Appeal Decision

Appeal Ref: APP/R5510/D/23/3322717

1 Grove Close, Ickenham, Uxbridge UB10 8QN

EXISTING LOFT
FLOOR LAYOUT (1:50)

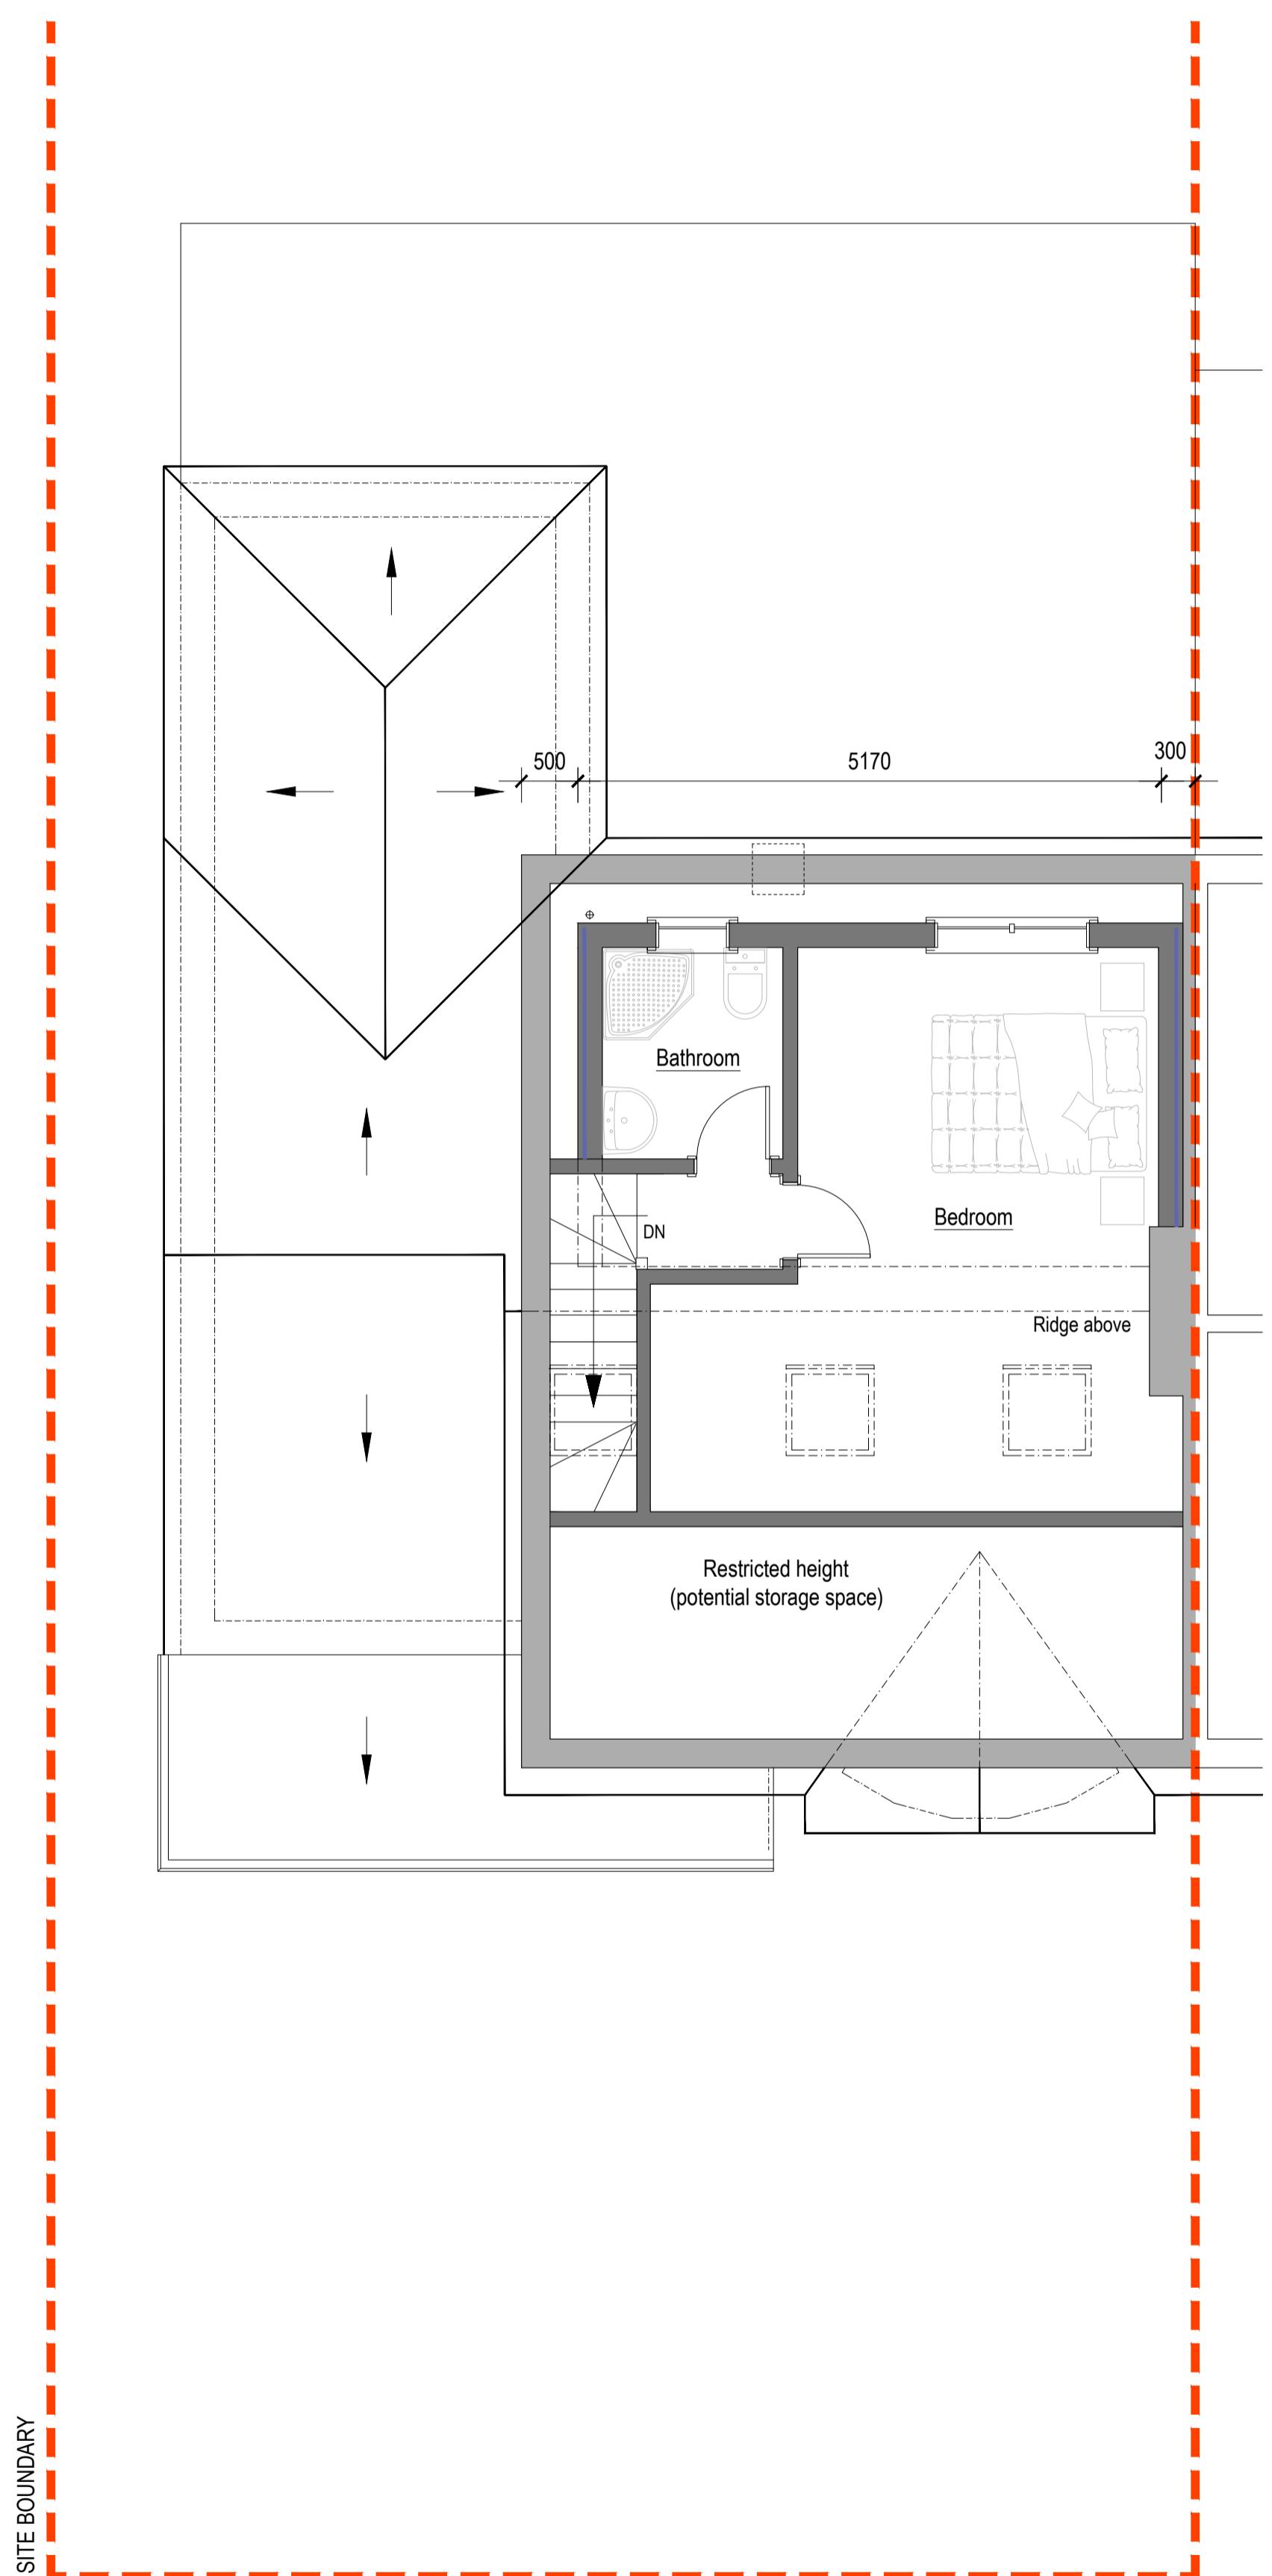
10. Turning to the rear, the dormer structure is a significant and domineering presence. It conflicts with policy DMHD 1 of the Hillingdon Local Plan Part 2 Development Management Policies (adopted 2020) which, amongst other things, indicates that a dormer should not exceed more than two thirds the average width of the original roof and should retain a substantial element of the original roof slope above the eaves line. The dormer has a flat roof and engulfs much of the rear main roof slope. It is box-like and stark and draws the eye, disrupting the proportions of the dwelling's rear elevation. The overdeveloped appearance of the rear of the property is exacerbated by the hipped roof over the side/rear first floor extension as this brings in an additional roof profile to add to the plethora of roof forms. In short, there is a poorly designed combination of roof extensions.

EXISTING FRONT ELEVATION (1:50)

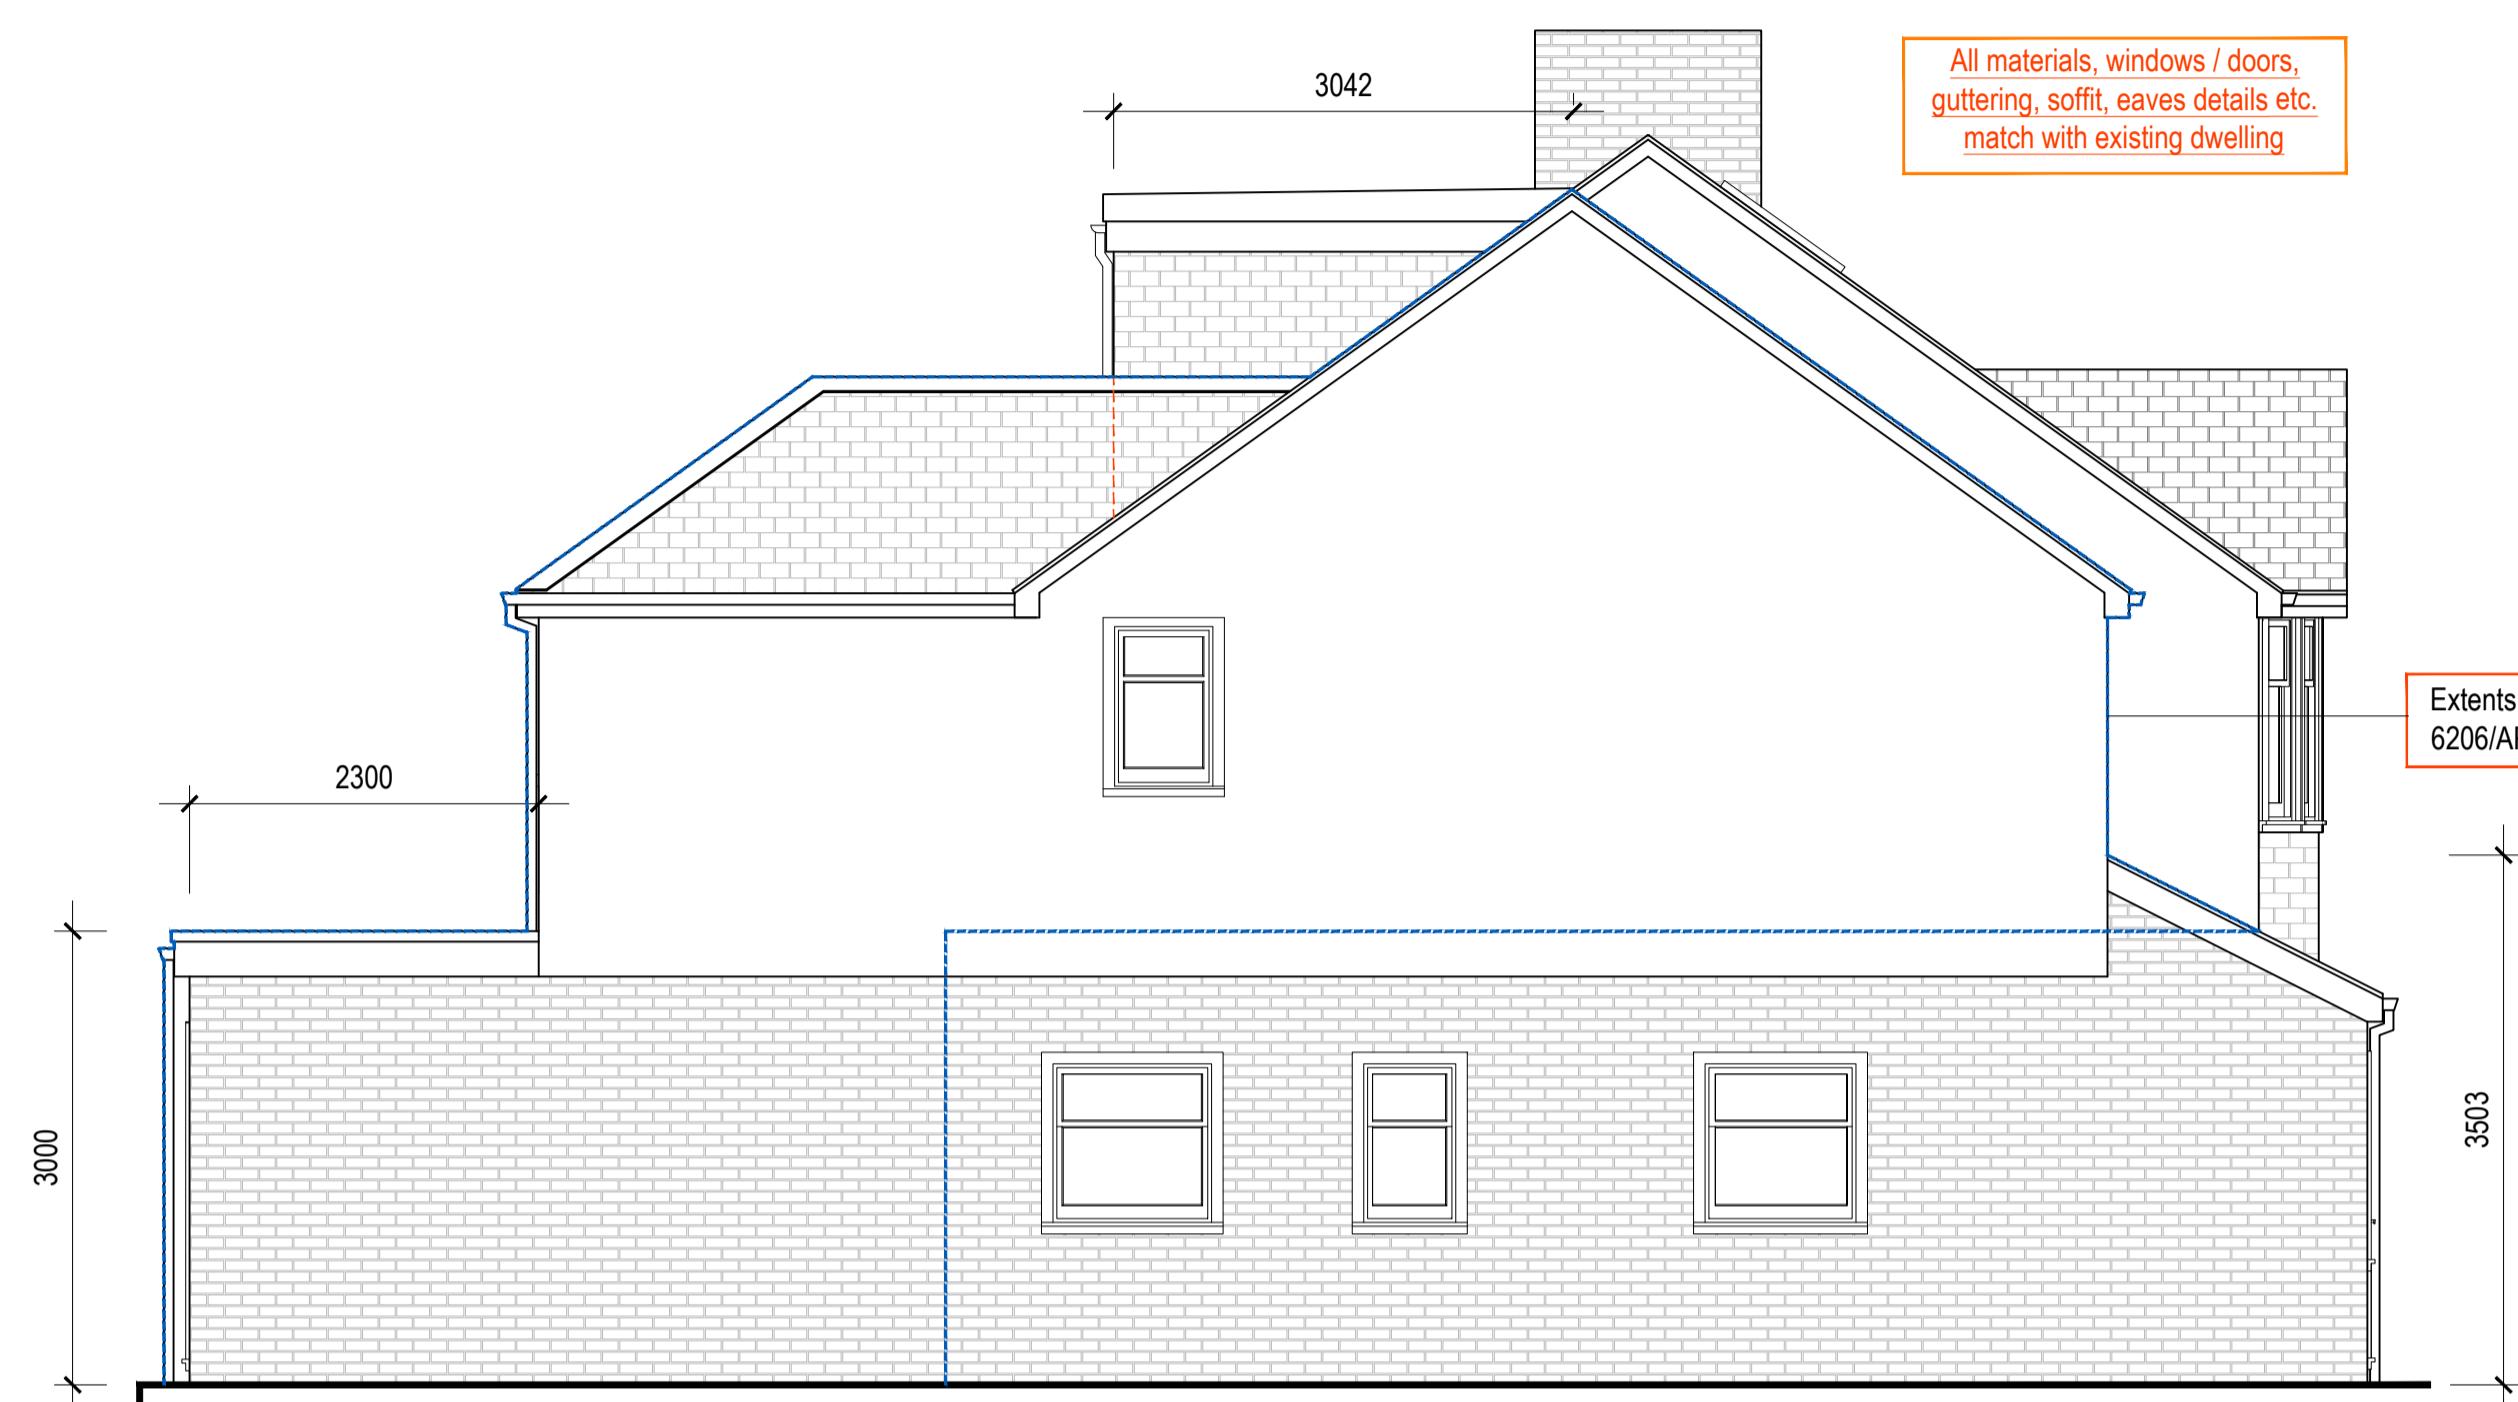
9. The main focus of the appeal relates to the roof alterations and extensions. In respect of the appearance of the dwelling from the front, the gable end roof design is unsympathetic, gives a top heavy appearance and does not read as a subordinate addition to the host dwelling. The roof alterations have resulted in an expanse of roof and a roof profile which unbalances the dwelling when viewed with its semi-pair (no.3) from the front. No.3 Grove Close has been extended to the side but the hipped roof profile has been maintained. Looking more widely within the cul-de-sac, the hipped roof profile is prevalent and is a broadly uniform characteristic of the streetscene. Other examples of side extensions in the cul-de-sac even those which include roof additions are more skilfully designed and considered, relating closely to their neighbour to ensure a sense of balance from the front. The appeal site does not reflect these characteristics or consistency. It is harmful to the two semi-detached dwellings when viewed together, as well as harmful to the wider streetscene.
